March 17, 2015

**RE: Response to City Staff Review Comments
Final Site Plan Application
Hotel Redevelopment
1210 Brighton Avenue
Portland, Maine**

We have reviewed the City staff comments provided for the Final Site Plan Application. Please find our responses to the comments below in *italics*.

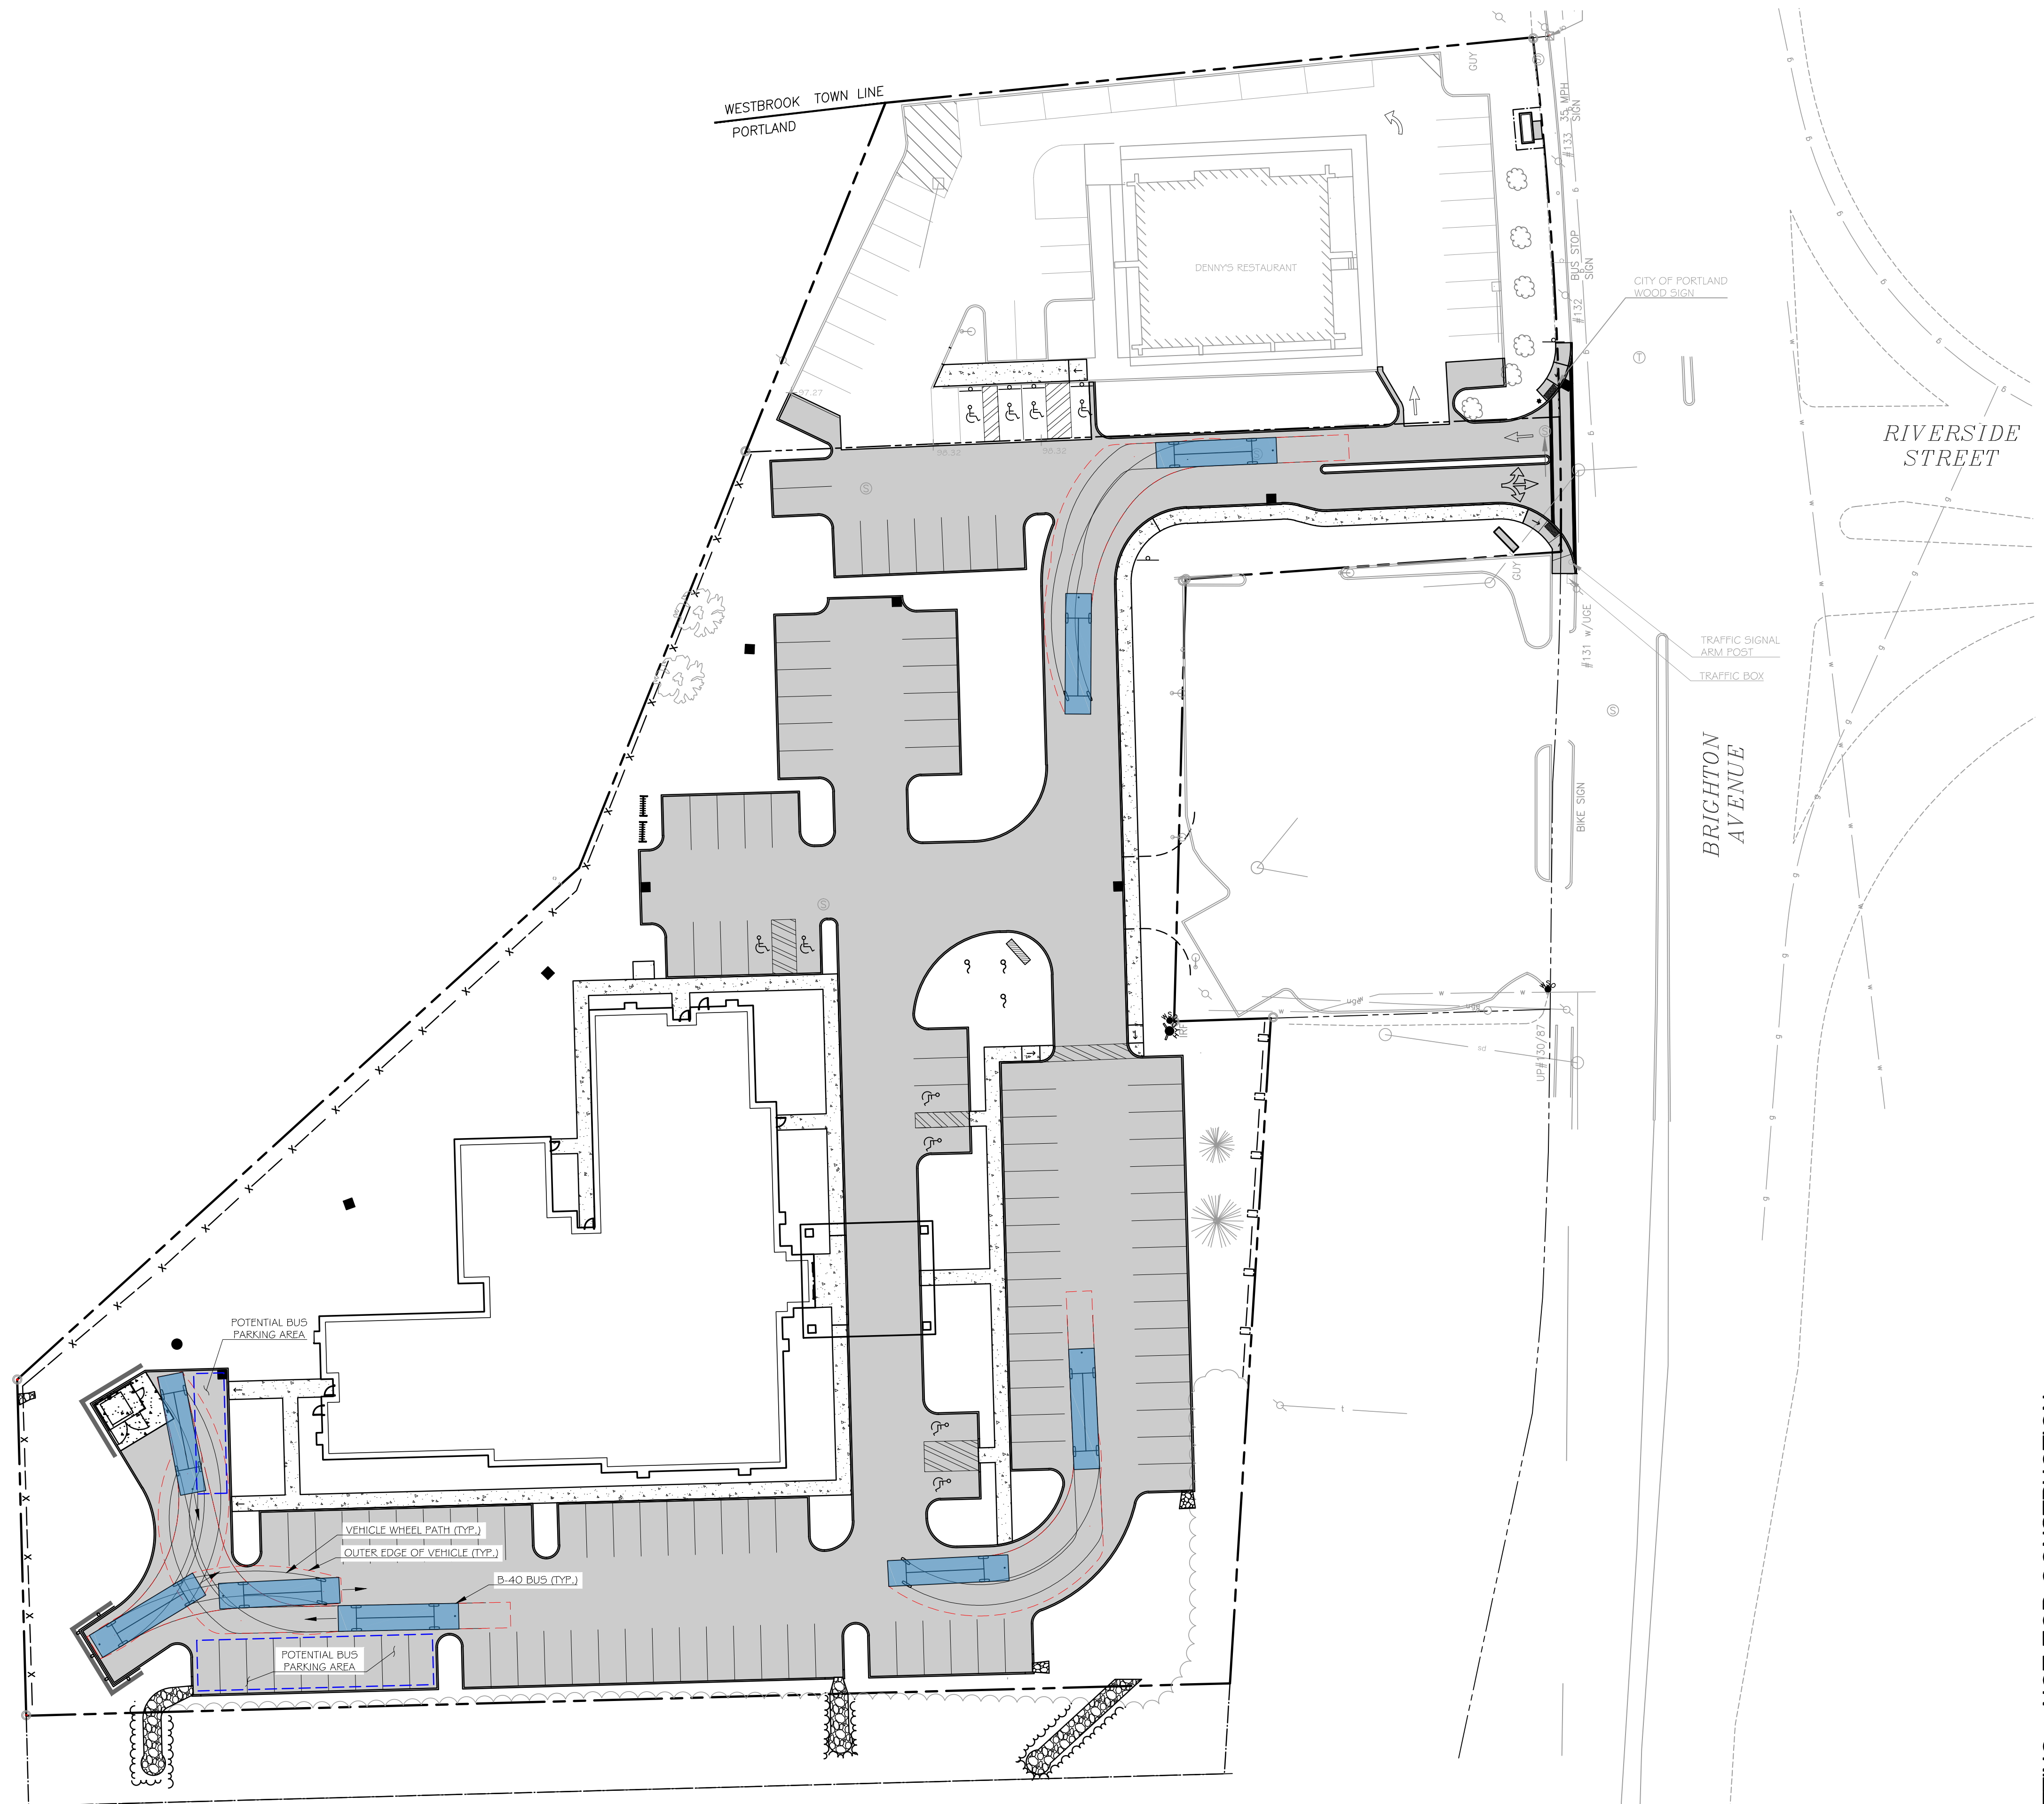
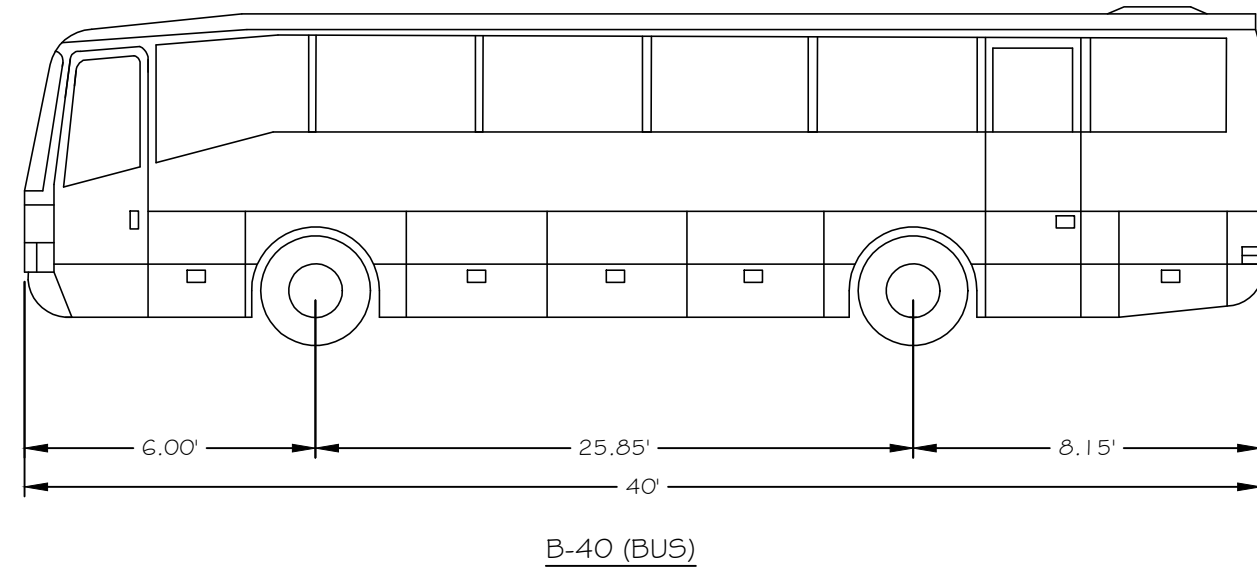
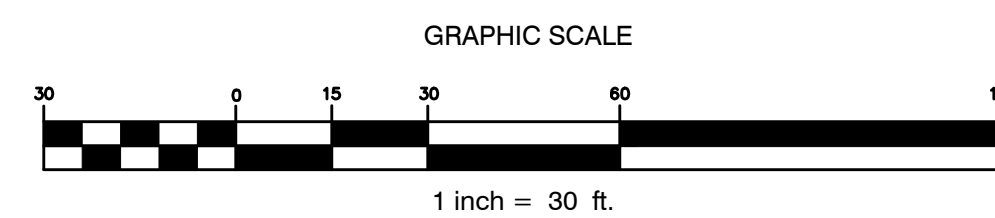
1. How will a tour bus be accommodated if a group of people wants or needs to stay at the hotel? Can a tour bus maneuver in the parking area?

A Bus Maneuvering Plan has been provided with this submission showing that a tour bus (B-40 vehicle) can enter the parking lot, turn around near the dumpster at the rear of the parking lot and exit the parking lot. A charter bus typically carries 45 to 60 passengers. Assuming 2 people per hotel room, the tour would require an equivalent of 23 to 30 parking spaces. The charter bus would be able to utilize these equivalent spaces for parking. Typically, bus tours are arranged prior to arrival, which will allow hotel staff to delineate a bus parking area ahead of time so that adequate spaces are available. In the unlikely event that there are not enough adjacent parking spaces available, the bus can park parallel to the curb near the dumpster. Potential bus parking areas are shown on the enclosed plan.
